Item No. **Report of the Head of Planning, Transportation and Regeneration**

Address 31 MORELLO AVENUE HILLINGDON

Development: Change of use of 3-bed dwelling to 5-bed HMO (Use Class C4) (Part Retrospective)

LBH Ref Nos: **72026/APP/2018/2672**

GROUND FLOOR PLAN - 1:50

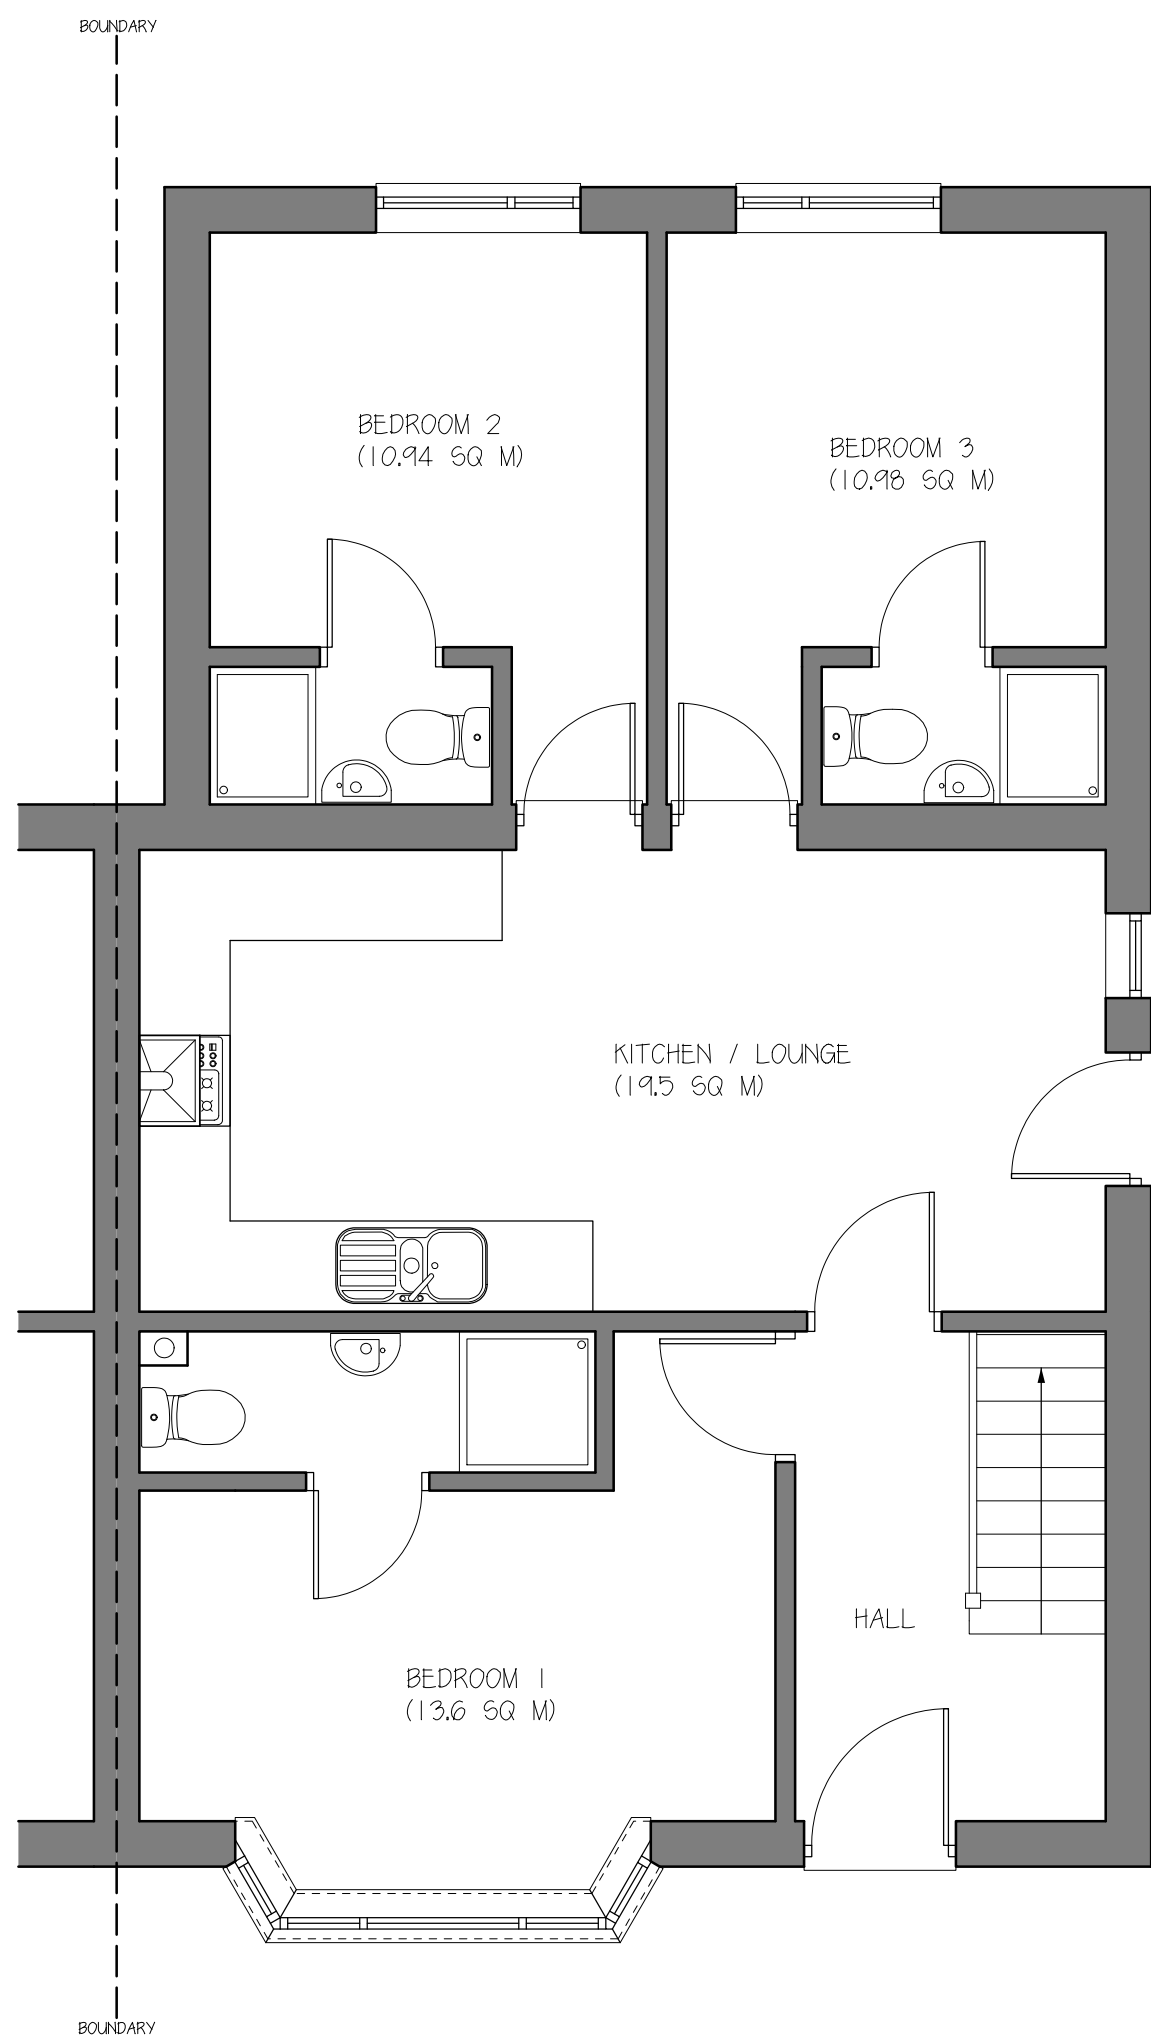
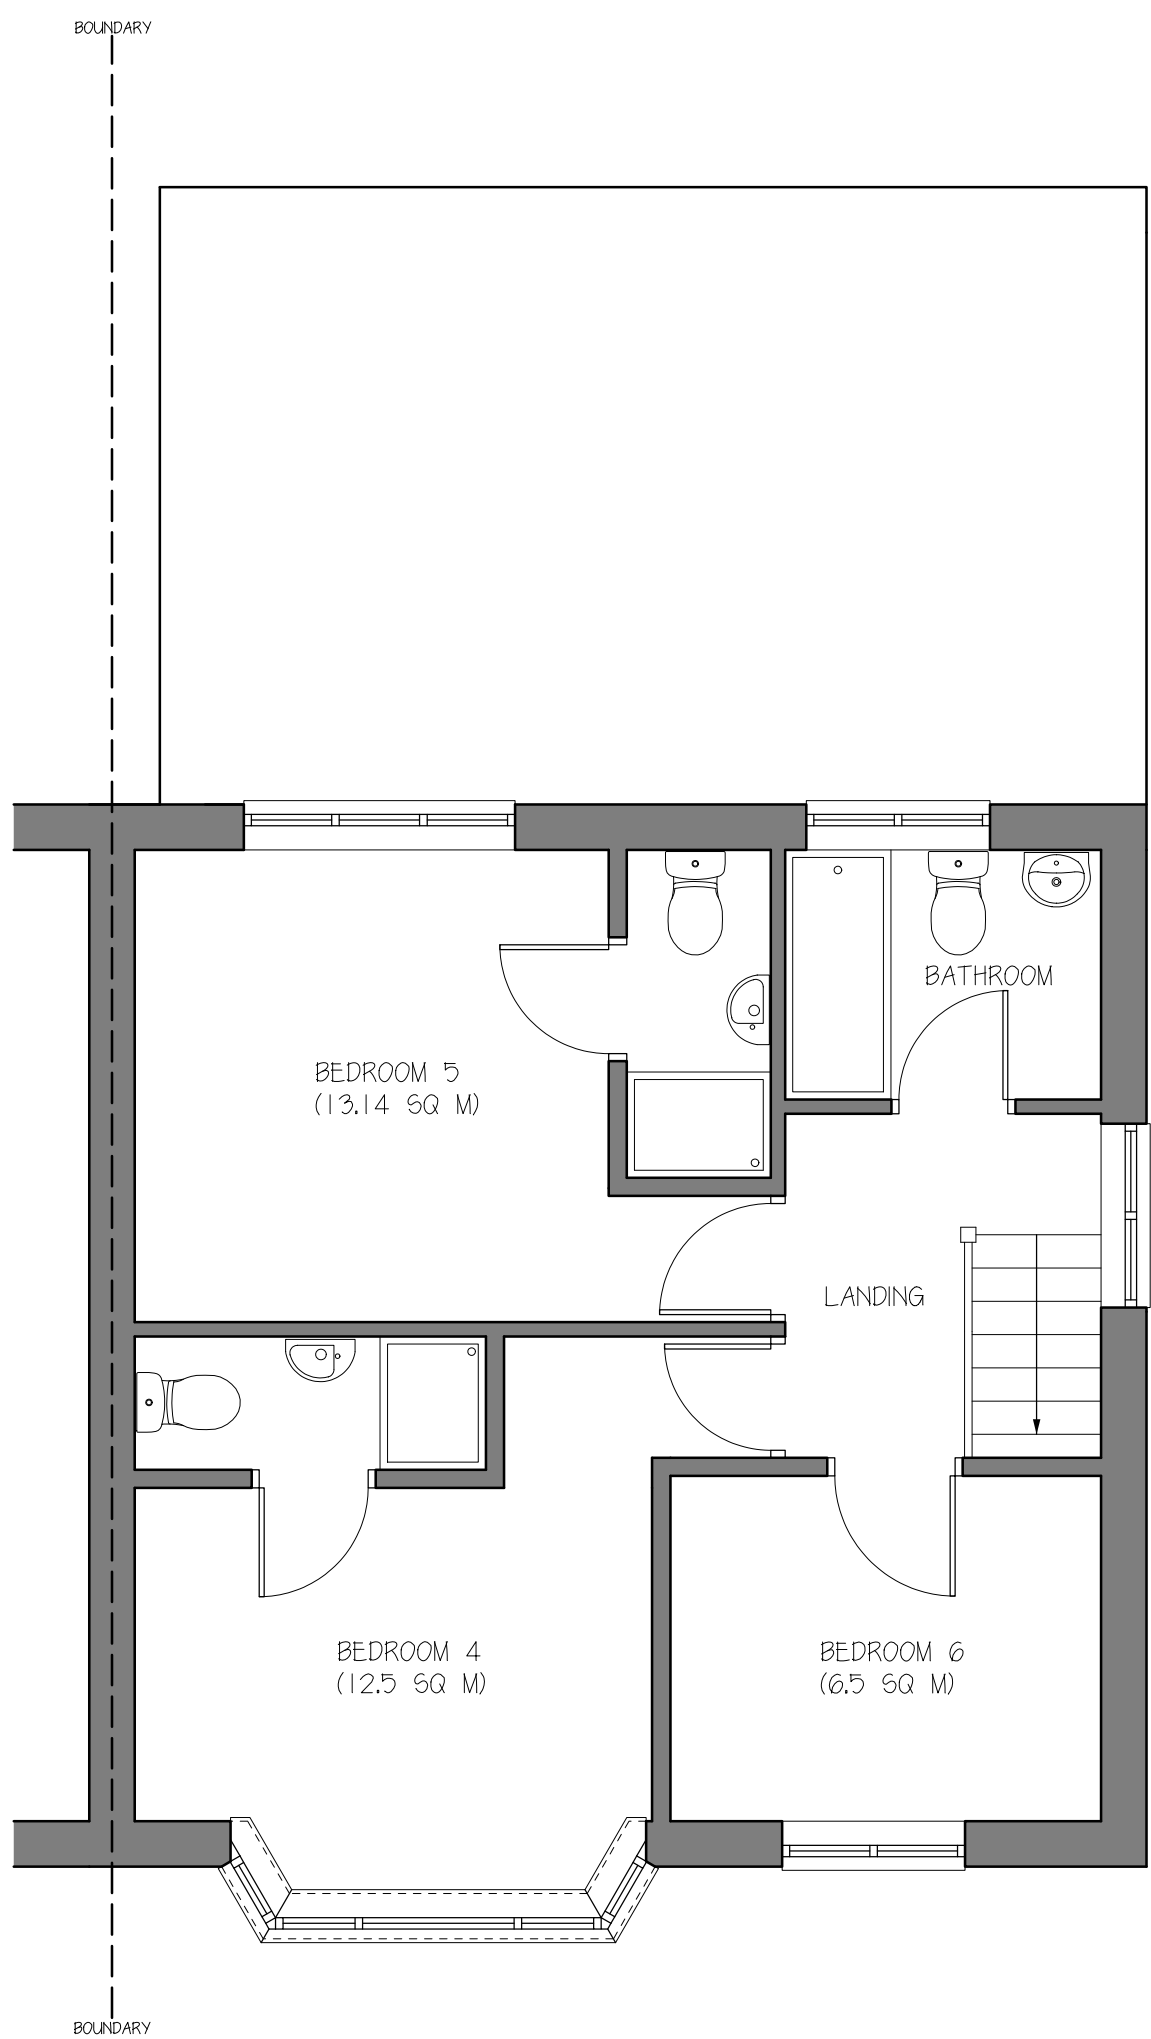
Bedroom 1 - 13.6 sq.m (en-suite)
lounge- 10.94 sq.m (en-suite) and door removed to integrate with kitchen diner (19.5 sq.m)
Bedroom 2 - 10.98 sq.m (en-suite)
Bedroom 3 - 12.5 sq.m (en-suite)
Bedroom 4 - 13.14 sq.m (en-suite)
Bedroom 5 - 6.5 sq.m

The National Space Standards, reflected in the Mayor of London's Housing Standards Minor Alterations to The London Plan (March 2016) requires a single room to have a minimum internal floor area of 7.5 square metres. Bedroom 5, at a floor area of 6.5 square metres, fails to meet this minimum standard. As such, the proposal fails to provide a satisfactory level of amenity to the occupants of a habitable bedroom by way of a substandard floor area in conflict with London's Housing Standards Minor Alterations to The London Plan (March 2016) and Policies BE19 and BE20 of the Hillingdon Local Plan: Part Two - Saved UDP Policies (November 2012).

"The communal kitchen/lounge provides the only shared living space for future occupiers. It is a fairly long room, lit at one end by a small window and an obscured glazed door. The openings face the side boundary wall of the property at a distance of around 1.5m and the two storey flank wall of the neighbouring dwelling at a distance of some 4m. As such, the outlook from the room is very restricted and only a small area of sky is visible from much of the room. Moreover, the kitchen area in particular, which is furthest from the window and door, is poorly lit and it would be difficult to carry out day to day activities without the use of artificial lighting.

The current proposal attempts to overcome this concern by the use of the original rear facing en-suite bedroom 2 as a communal lounge which would be linked to the communal kitchen dining area by the removal of an internal door. Whilst it is acknowledged that the use of the en-suite room within the rear extension would provide a communal room with appropriate levels of light and outlook, concerns remain in terms of the level of amenity enjoyed by the use of the future tenants of the kitchen/dining room. The removal of the single door would provide restricted rearwards views. However prevention of a door being reinstalled by condition would be difficult to enforce. Furthermore, the restricted views through this doorway towards the rear garden are not considered to overcome the concerns raised in terms of the light and outlook enjoyed by the occupants of the kitchen/dining room. The proposal would therefore fail to provide a satisfactory residential environment for the future occupants of the HMO given that the communal kitchen/diner would achieve very poor levels of outlook and light. The proposal is therefore contrary to Mayor of London's Housing Standards Minor Alterations to The London Plan (March 2016) and Policies BE19 and BE20 of the Hillingdon Local Plan: Part Two - Saved UDP Policies (November 2012).
